WEST SUSSEX COUNTY COUNCIL CONSULTATION

TO:	Arun District Council FAO: Michael Eastham
FROM:	WSCC - Highway Authority
DATE:	10 November 2021
LOCATION:	Land to the south of Ford Lane and East of North End Road Yapton BN18 0DS
SUBJECT:	Y/123/21/PL Variation of condition imposed under Y/82/20/RES relating to condition 1 - plans condition. Revised Plan submitted.
DATE OF SITE VISIT:	n/a (Desktop study)
RECOMMENDATION:	No highway objection
S106 CONTRIBUTION TOTAL:	n/a for purposes of this specific planning application

This is the second WSCC Highways (CHA) response to the above planning application for variation of condition imposed under Y/82/20/RES relating to condition 1 - plans condition.

**Title:**  
PLANNING LAYOUT

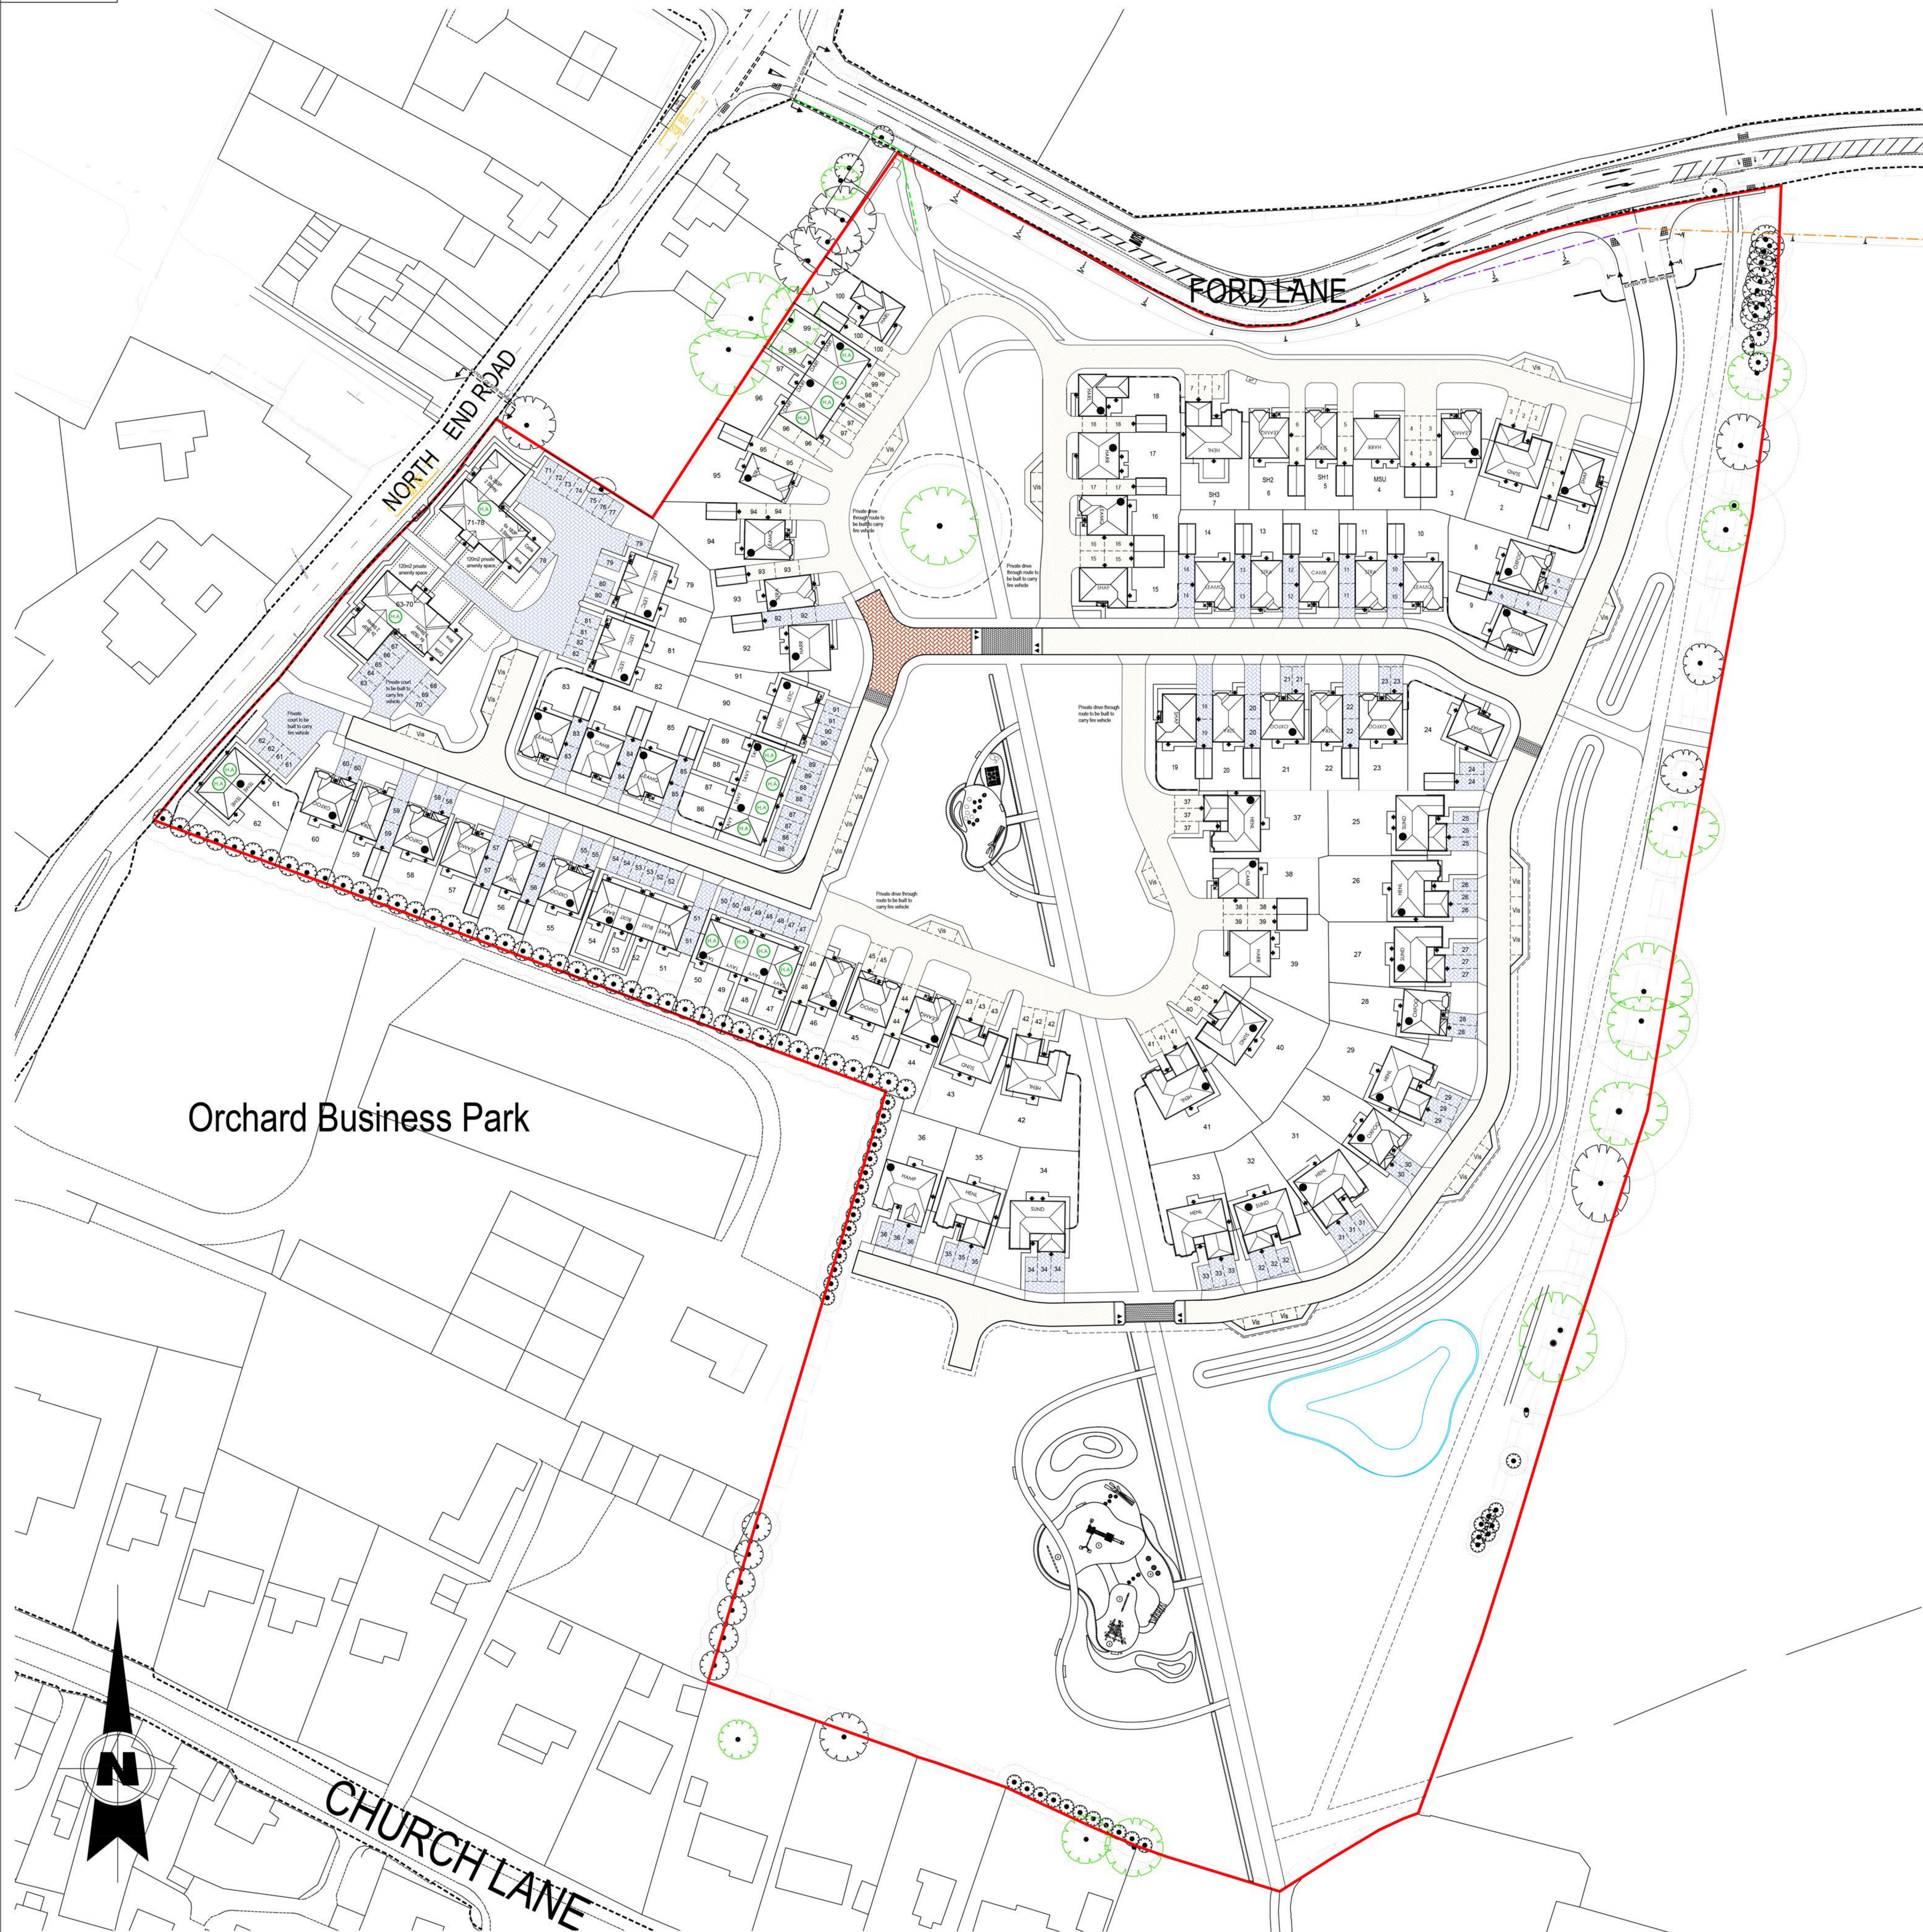
In its previous response dated 20 October 2021, the CHA identified an area of concern with the proposals – namely the revised position of the turning head found on the southern-most access road. Where it was shown bisected the line of Public Footpath No. 357. While the legal line of the PRow did not appear altered it did make any future upgrading to either a cycle route or bridleway potentially difficult given the alignment and purpose of the turning head to turn vehicles. This is because any future upgrading is likely to require physical alterations to the road surface in an attempt to give non-motorised users priority in accordance with latest design guidance and having the turning head in the position as currently proposed will make this difficult to achieve. As such, the CHA required that the turning head be moved off the legal line of the PRow.

In reply to this, the applicants have provided Drawing No. D2831-FAB-00-GL-DR-L-0100 Revision 'PL15' produced by Fabrik Landscape Architects. The turning head shown is now found to the west of the PRow and thus does not obstruct it. With regard to its size, it is slightly smaller than originally proposed (and those found elsewhere within the estate road layout) but still appears to provide sufficient space for a refuse vehicle to be able to undertake a three-point-turn.

Based on the above, no highway objection is raised.
